**NIHON UNIVERSITY NEWCASTLE CAMPUS 9 CHURCH STREET NEWCASTLE
(SSD 9787)**

The submitted application and Environmental Impact Statement (EIS) have been reviewed by CN officers and the following comments are offered for your consideration:

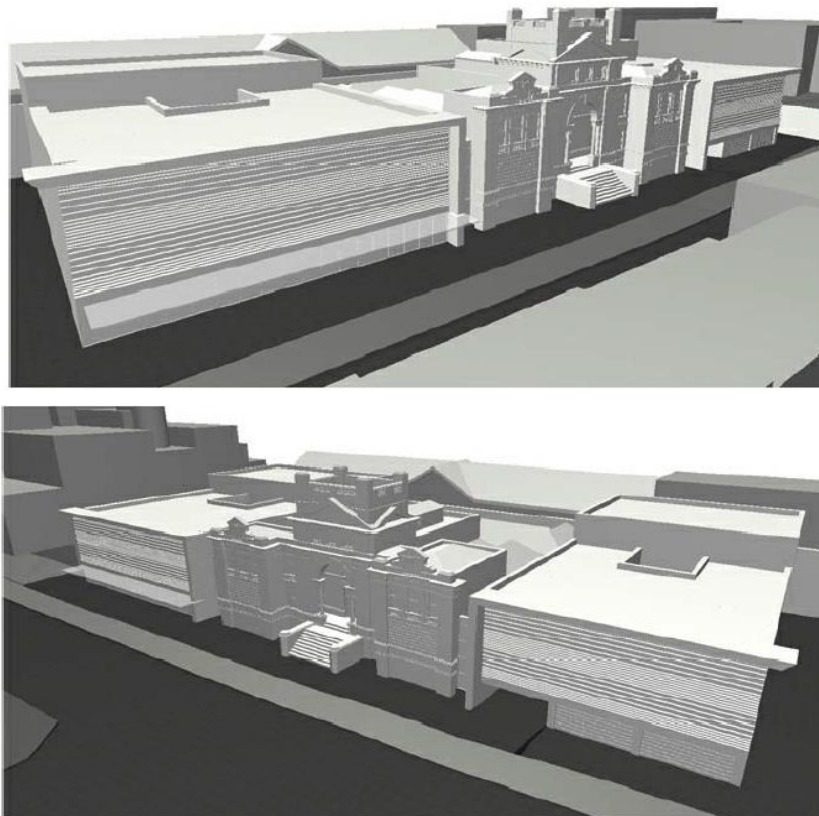
While the UDCG generally supported the massing strategy proposed, and the modern façade expressions of the new buildings on either side of the former courthouse, concerns were raised regarding the aesthetic expression of the new buildings.

1. *'The proposed buildings have a strong horizontal massing which is not in keeping with the character of the courthouse, or the urban fabric of this part of the city (look at the proportions of the terraces on Church Street). A combination of horizontal and vertical massing is needed in the façade to be a better fit with the area.'*

2. *'The façade expression is relatively similar for both the dormitory and the teaching buildings. While the two should (as the architects propose) have a similar language of texture, colour and materiality, the UDCG suggests that the next stage the different functions of the two could be expressed. As such, a smaller scale, richer façade might be found in the dormitory building, while a slightly larger scale, more commercially expressed version of the façade might be developed for the teaching building.'*

The applicants were encouraged to continue developing the façade design (in materiality, detail, texture of colour) to present the impression of an important educational building in an urban setting.

Based on an examination of the submitted plans it would appear that the design of the development has been modified in response to some of the above comments. However, it would be helpful if the applicant could provide a written narrative which provides specific details of the design changes made in this regard.

Extract from amended drawing A-108:

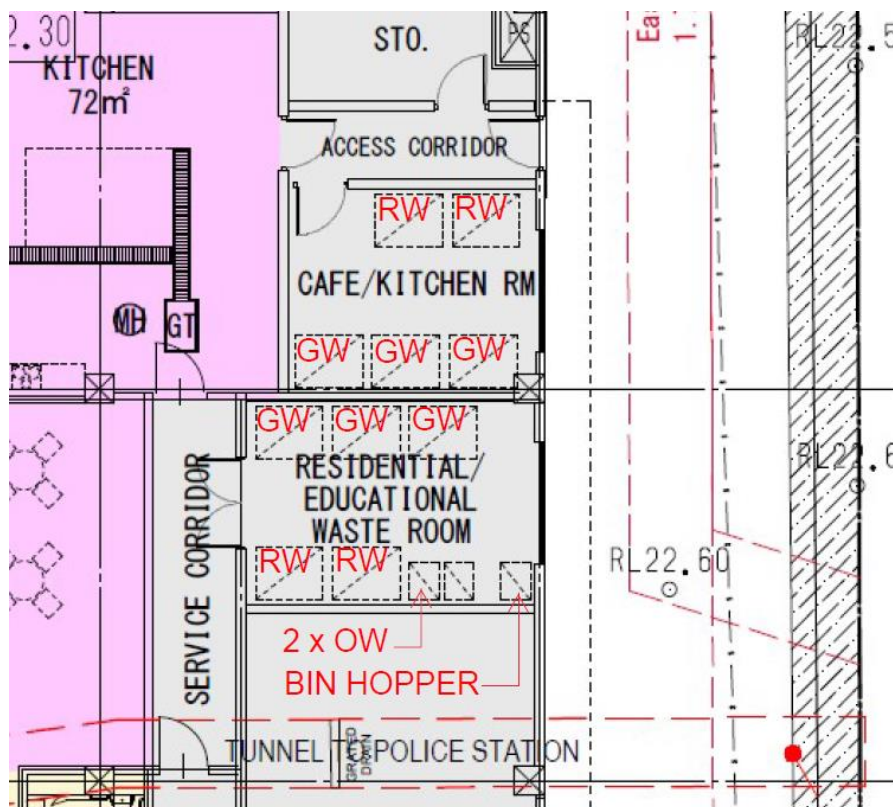
The design of the two waste bin storage rooms is:

- To be large enough to accommodate the entire fleet of bins plus 0.2m between bins to allow adequate maneuverability space.
- To provide a 1.8m unobstructed clearance zone between the stored bins and the entrance to permit access and maneuverability.
- To provide suitable dual door access for the service of bins with a minimum width of 1.8m and accessed by a 1.8m unobstructed access corridor.
- To be located within proximity to the on-site loading bay.
- To be fully enclosed, walled and not permit through access to other on-site waste infrastructure. Separate unobstructed access is required.
